Whalley Parish Council

3/2012/0824 Proposal: Change of use from booking office to walk in booking office. Change of parking to add more additional parking spaces

Location: Ground Floor Office 6 Abbey Works Back King St

OBJECTION

EXISTING AND PROPOSED LAYOUT

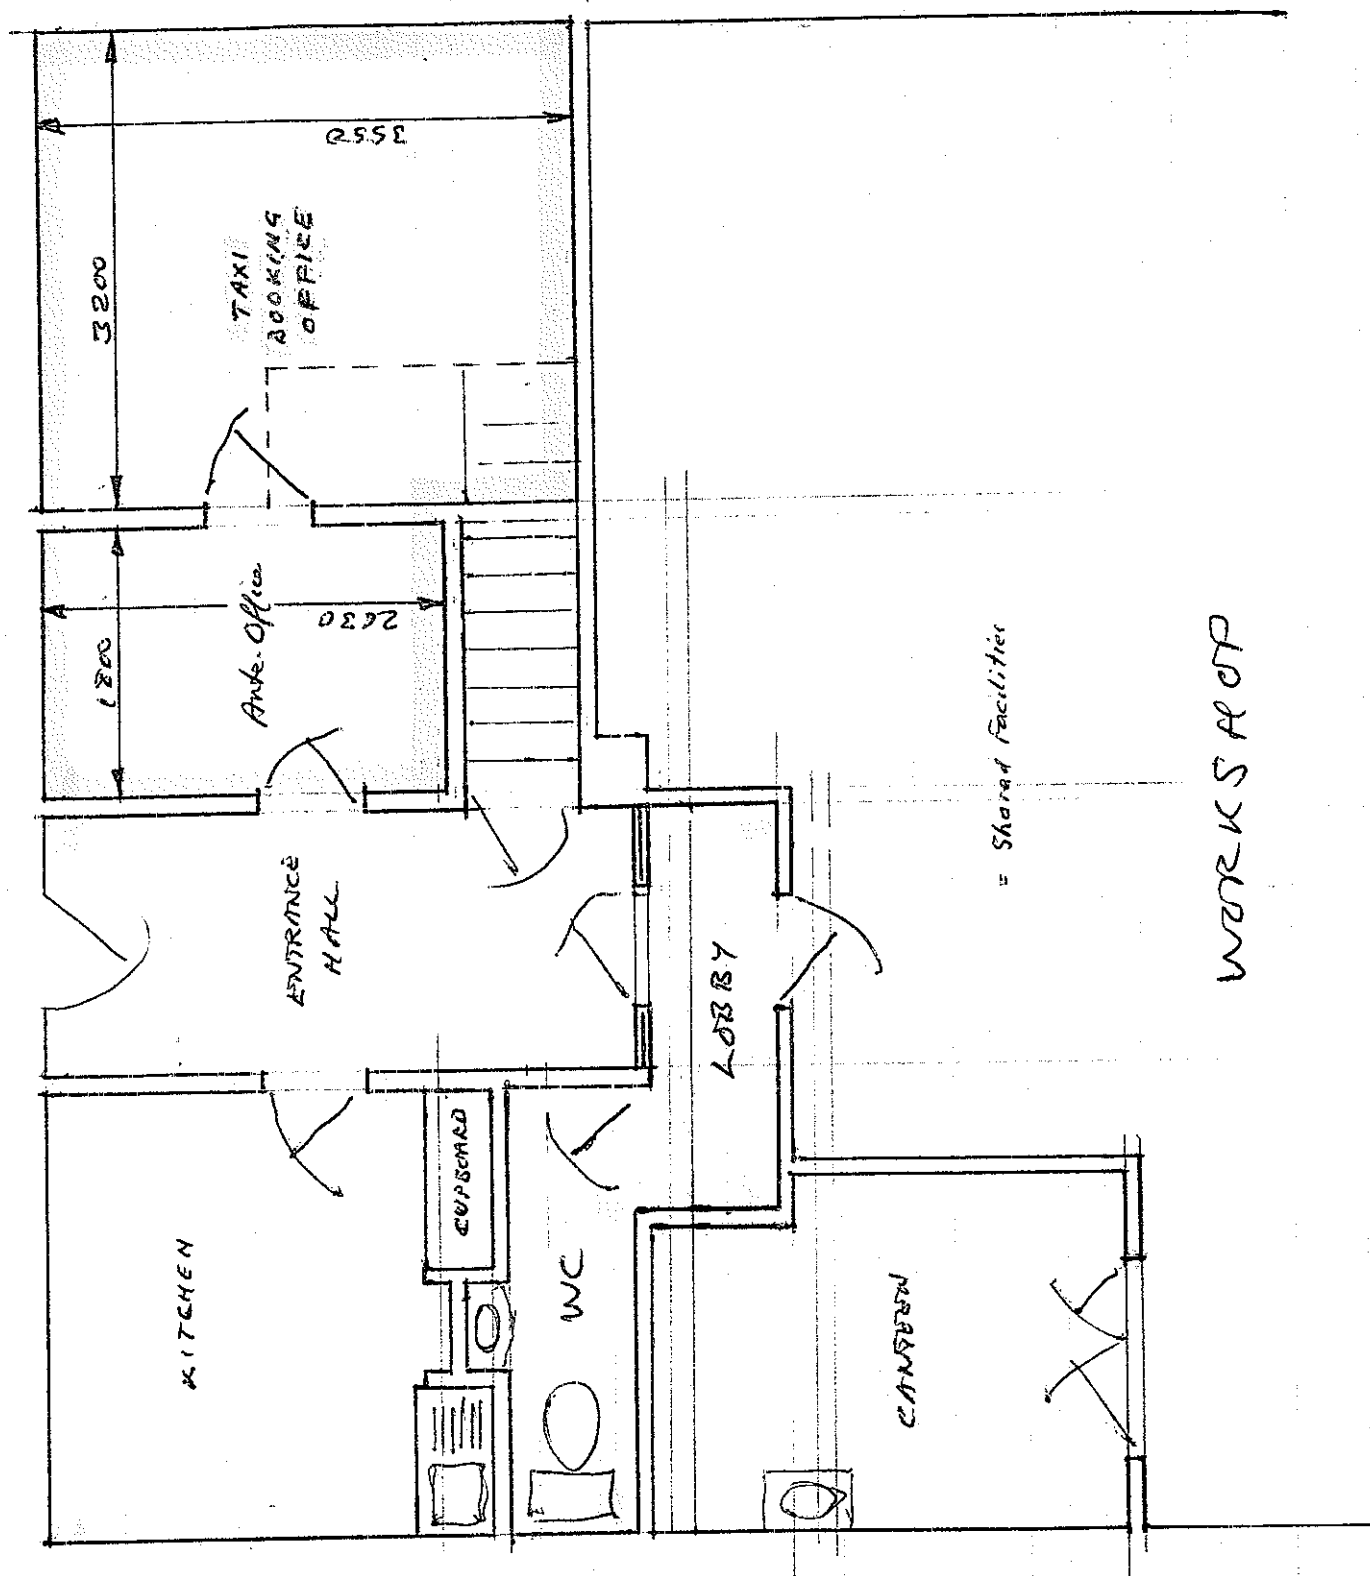
The Parish Council strongly object to this application as they did to the previous application 3/2009/0127. The concerns expressed at that time have reluctantly been proved to be correct. Permission had been granted (despite the parish council's objection) that the use of the building shall be of a private operators base only and there should not be available for the general public to book a taxi from the building or wait outside. The present proposal removes this condition irrevocably. It would be irresponsible to allow an application whereby prospective clients, walk along an unlit narrow road, without footpath, to an inappropriate back street building. To then increase the number of vehicles commuting to and from this building only increases the risk. This is untenable in a residential area.

The road to exit the premises onto King Street is unmade and unmarked. Road side parking and traffic congestion in Whalley centre will only be exacerbated.

Clearly Policy G1 of the Districtwide Local Plan in the interests of highway safety and the safeguarding neighbouring residential amenity would be ignored if this application were to be approved.

Rather than accept this proposal the parish council would welcome RVBC officers monitoring existing practice by a company which regularly and systematically ignores parking restrictions and time restriction which have been previously imposed.
